Ann Machado - Re: Permit #2013-01059 - 59 Riverton Drive

From: Stephen <stephengta2@gmail.com>
To: Ann Machado <AMACHADO@portlandmaine.gov>
Date: 6/3/2013 11:16 AM
Subject: Re: Permit #2013-01059 - 59 Riverton Drive
Attachments: SITE PLAN.pdf

LOCATION OF PROPOSED
DROP IN HEALTH
CENTER

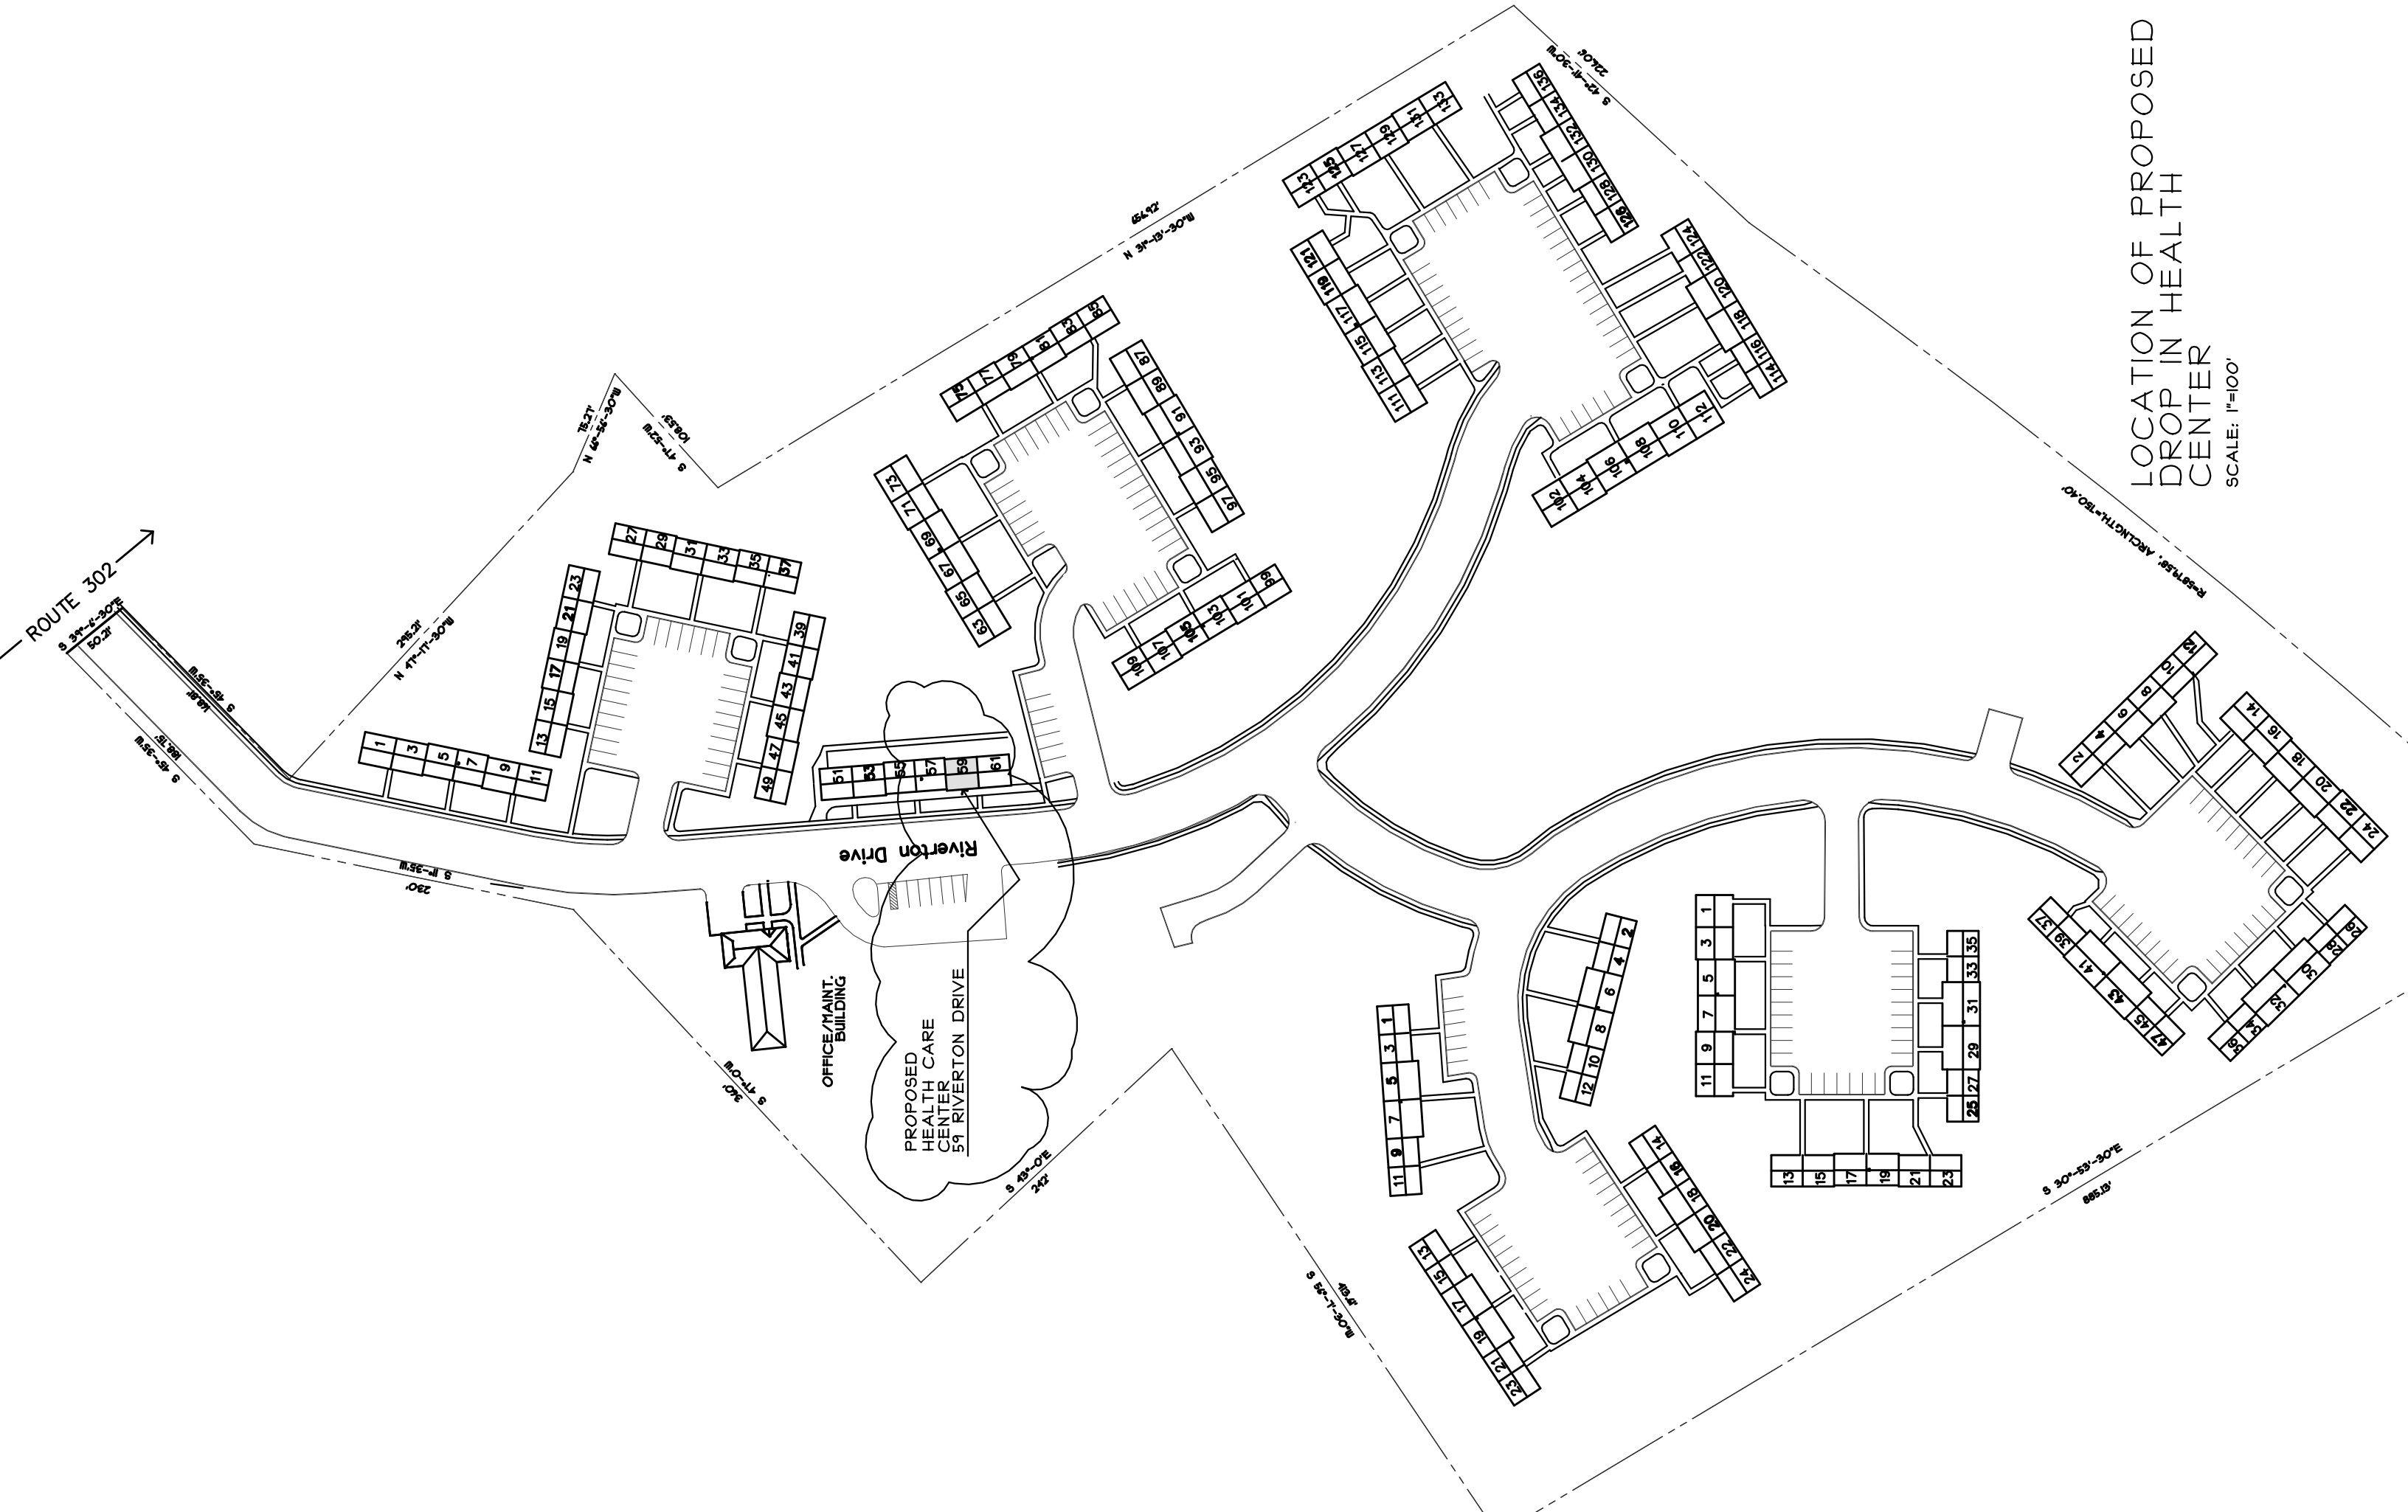
I was doing my zoning review for this permit, and I need some more information.

I need a site plan indicating where the proposed health center is located on the property.

**Good morning Ann,
I've attached a site plan with the location of the Heath Center.
The scale is 1"=100', if you need one at a larger scale, please let me know.**

The Health Center is for Riverton Park residents only, staffed initially for 2 hours per week by a nurse or nurse practitioner and possibly, at some times, a nursing student.
